1 No. two storey house (resubmission following A/87/18/PL). This application is a Departure from the Development Plan & affects a Public Right of Way.

Land between Ashurst & Badgers Ham Manor Way Angmering

Thank you for your internet representation made on 11th April 2019 which has been recorded as '**an objection**' with the comments as follows:

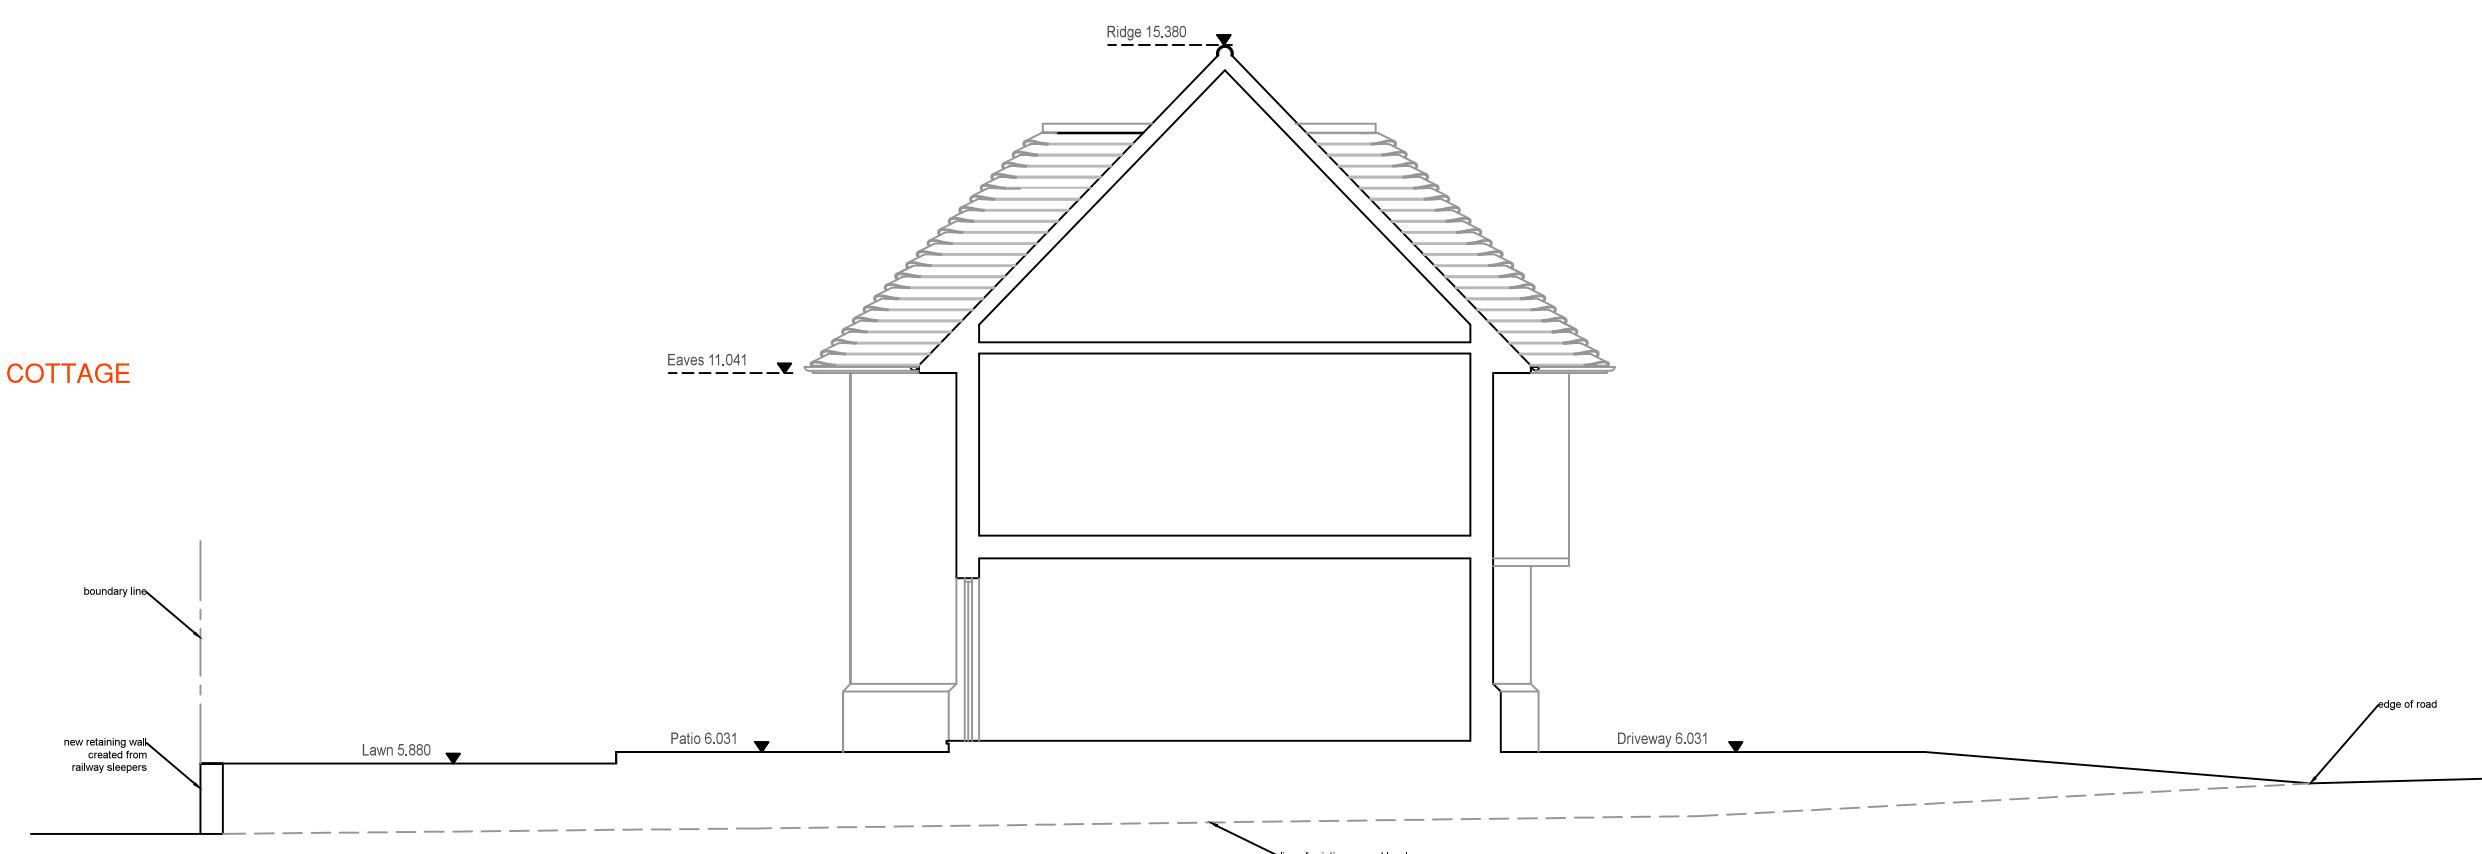
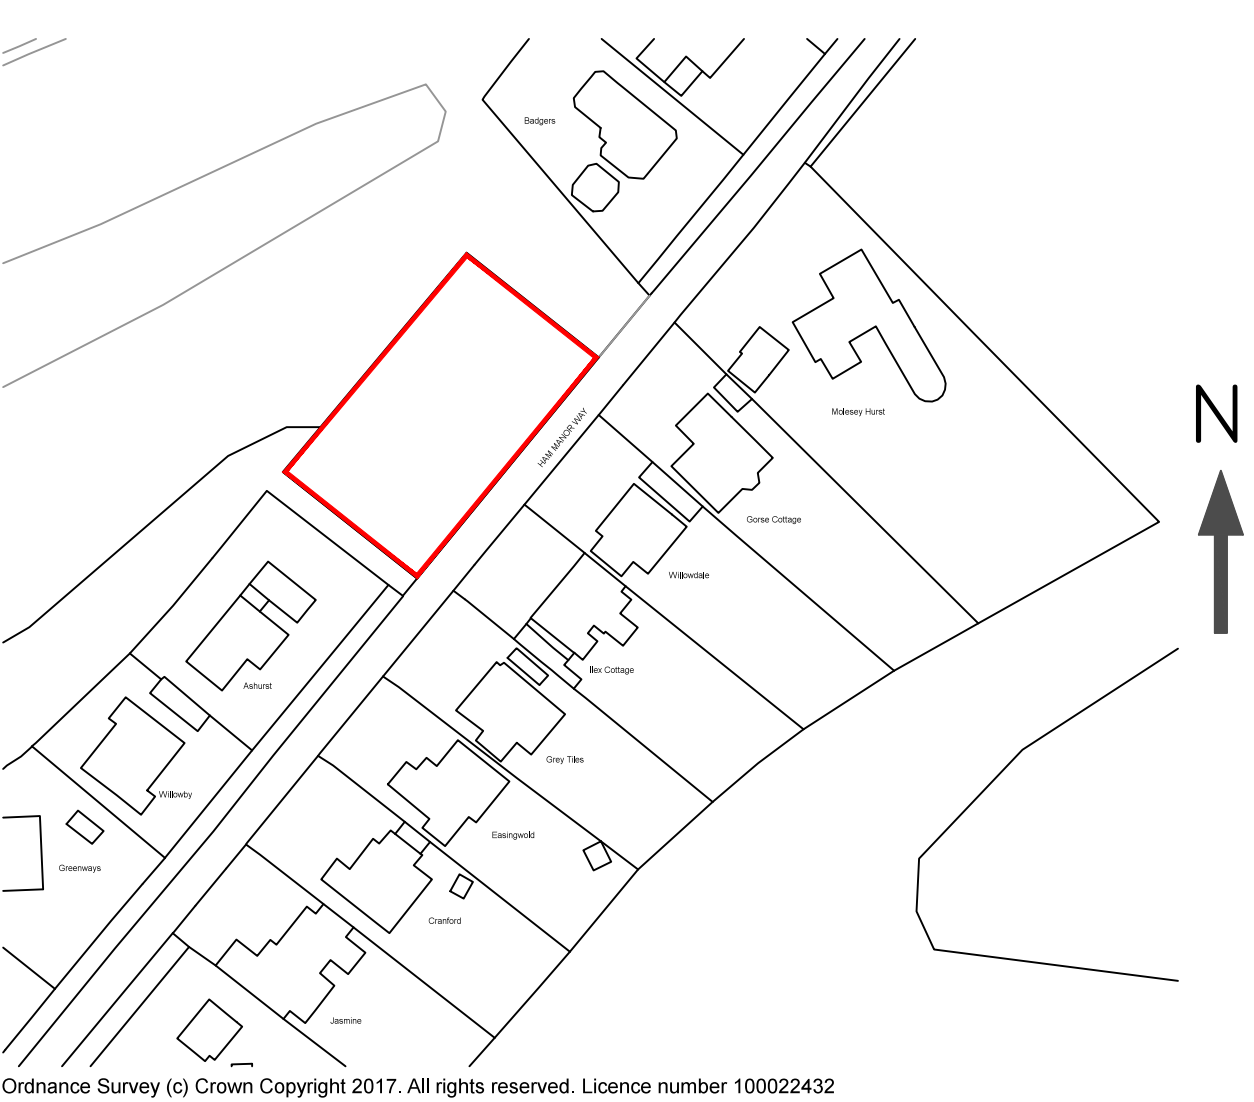
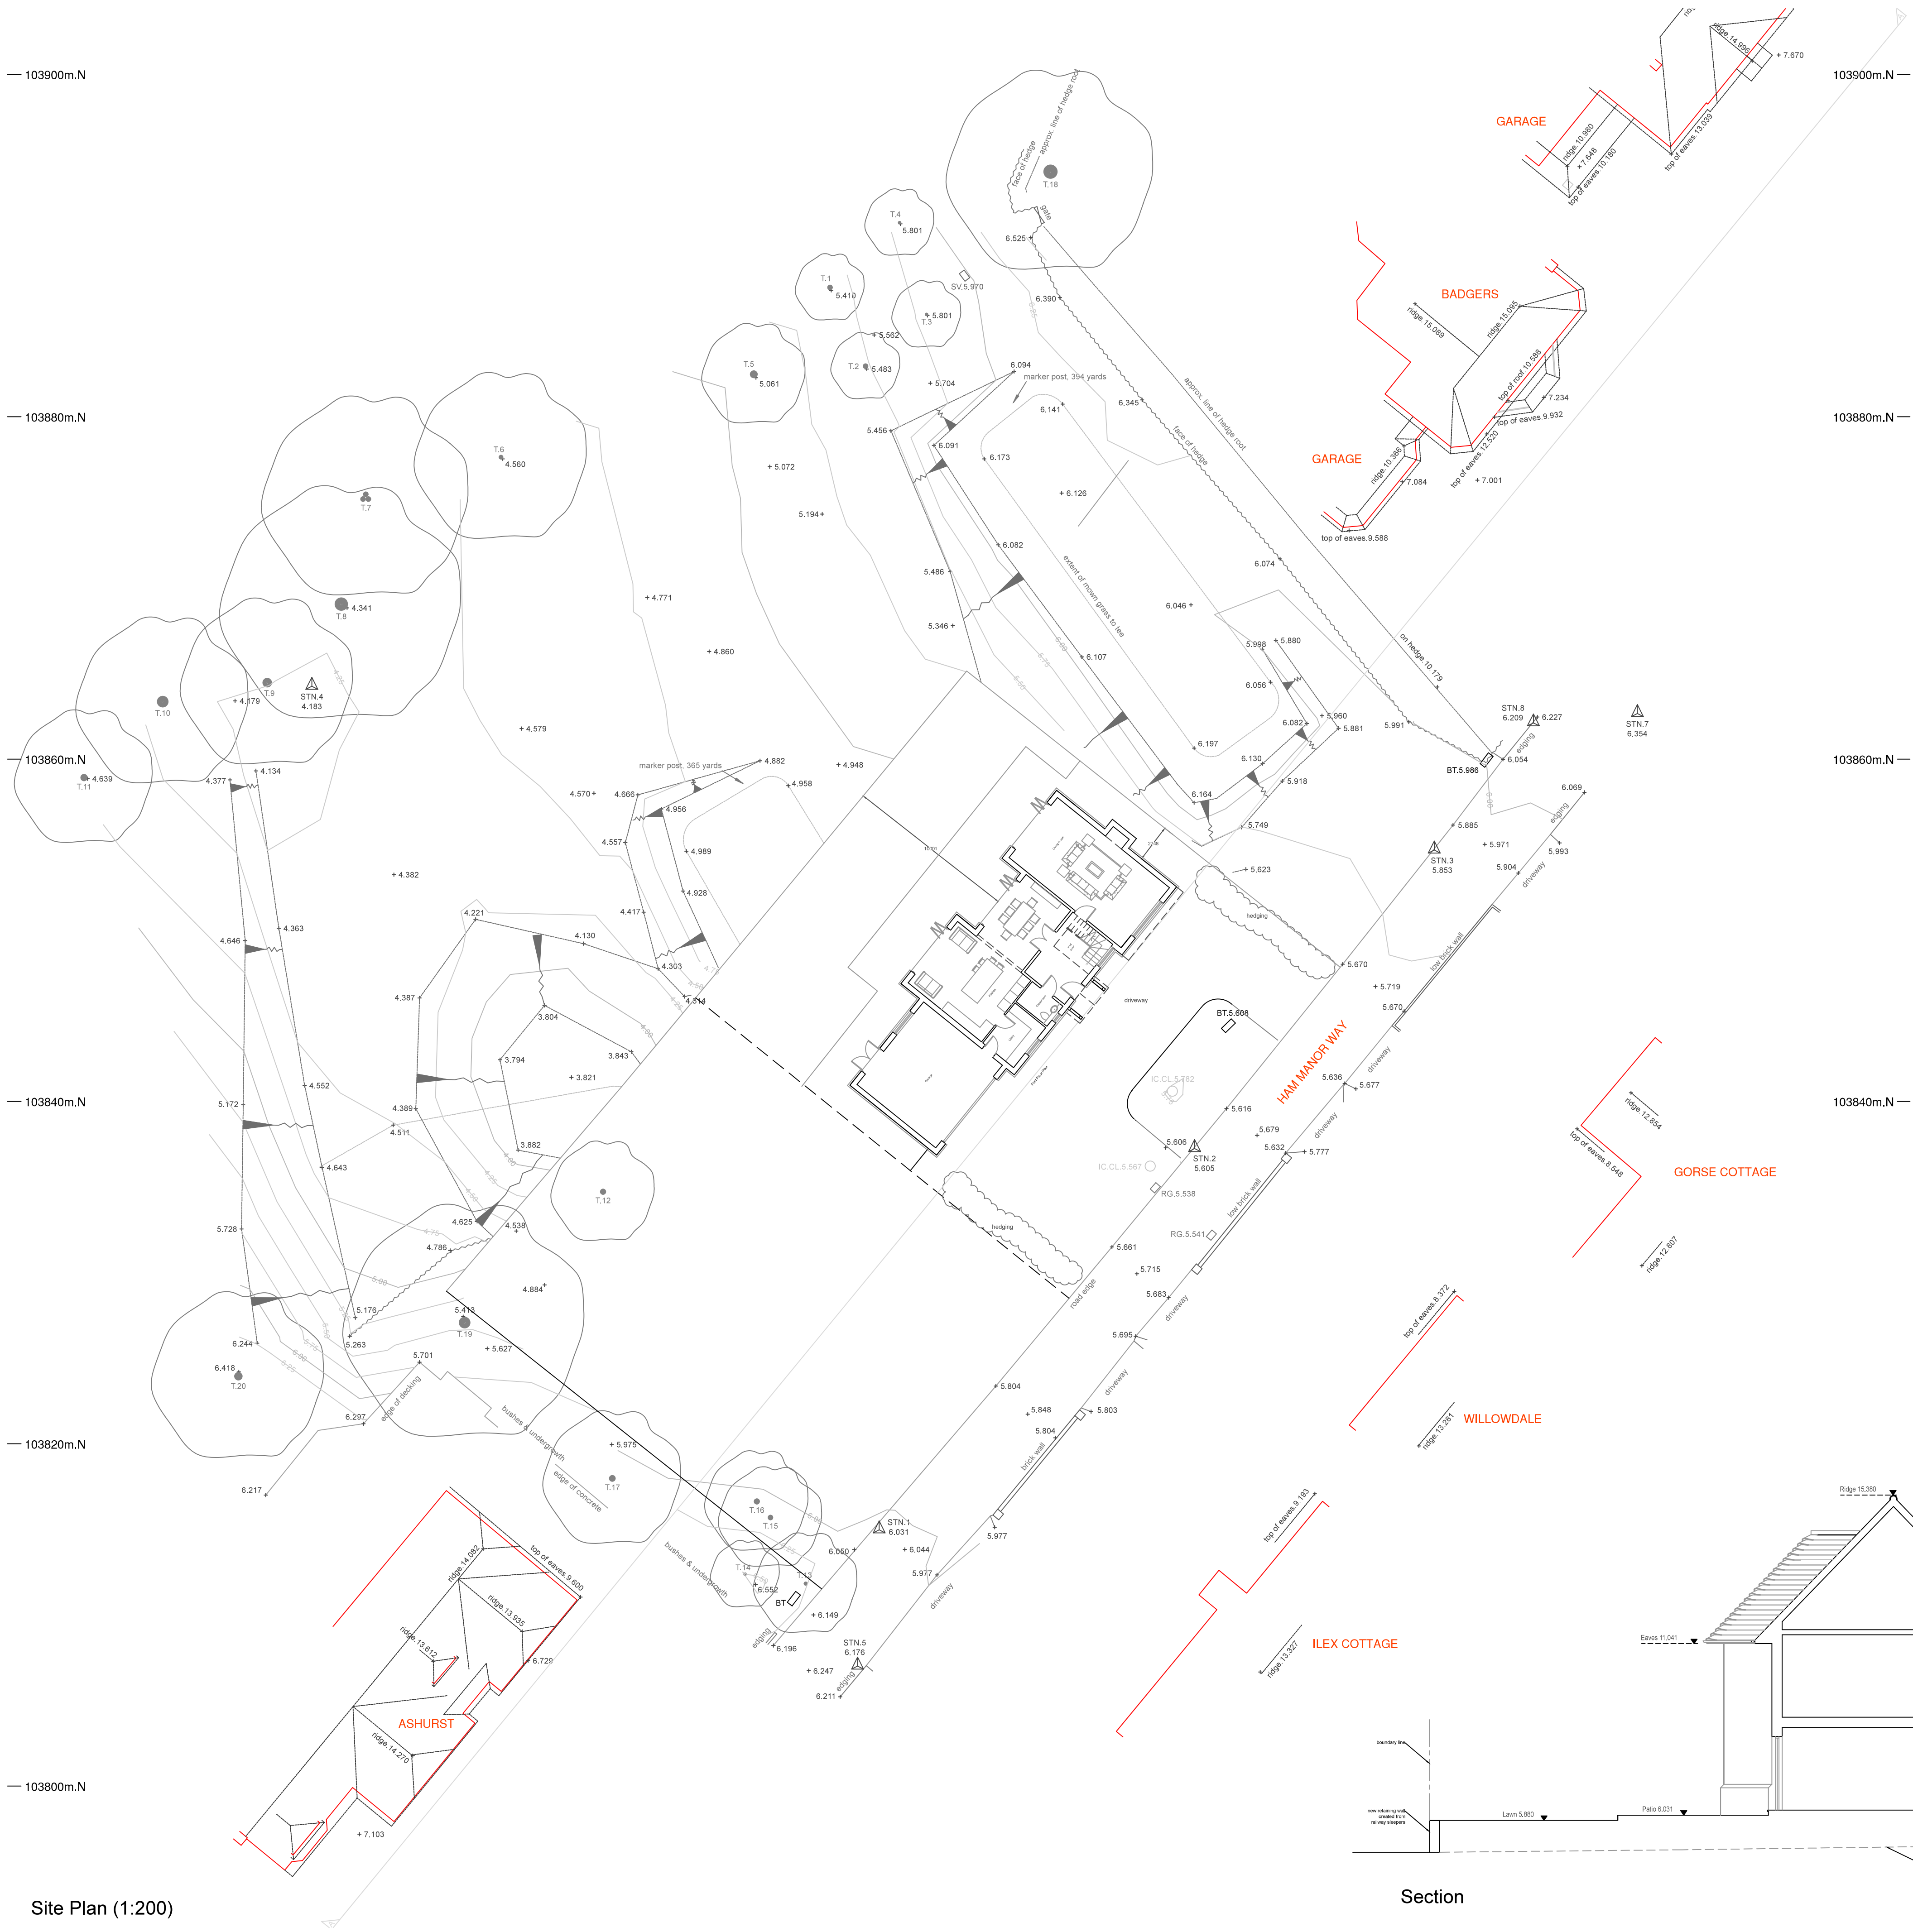
The property is far too far forward of the existing build line.

Street Elevation (1:200)

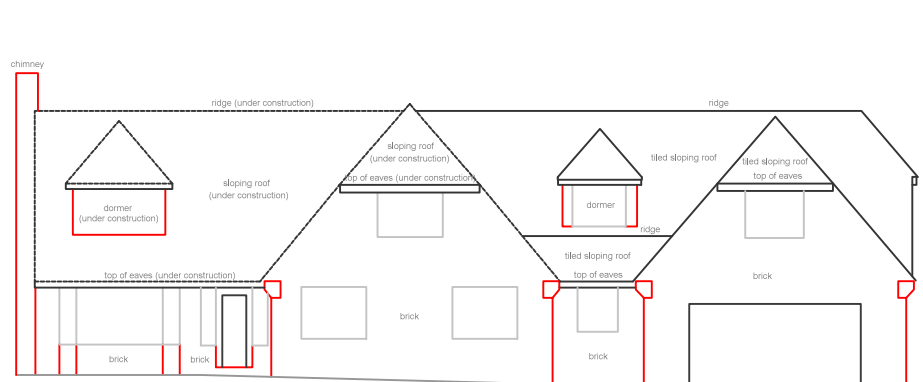
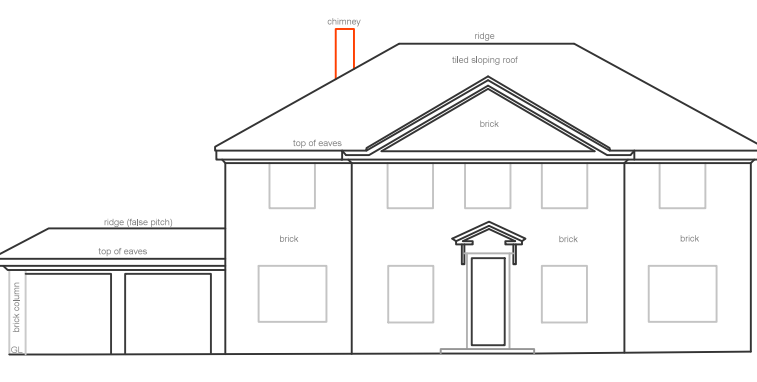
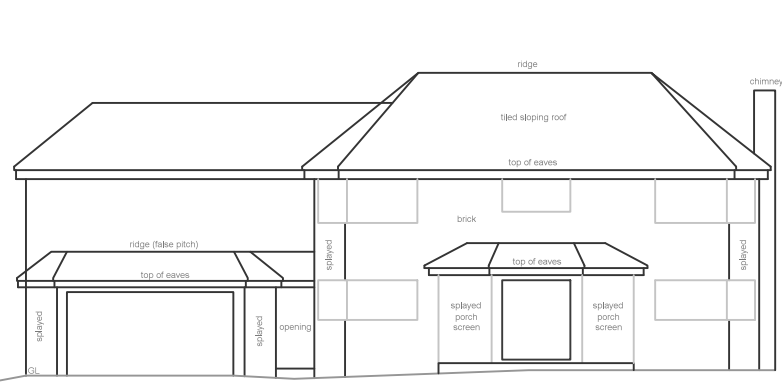
The property is far too big for the plot size.

Existing properties are mainly bungalow and chalet style housing.
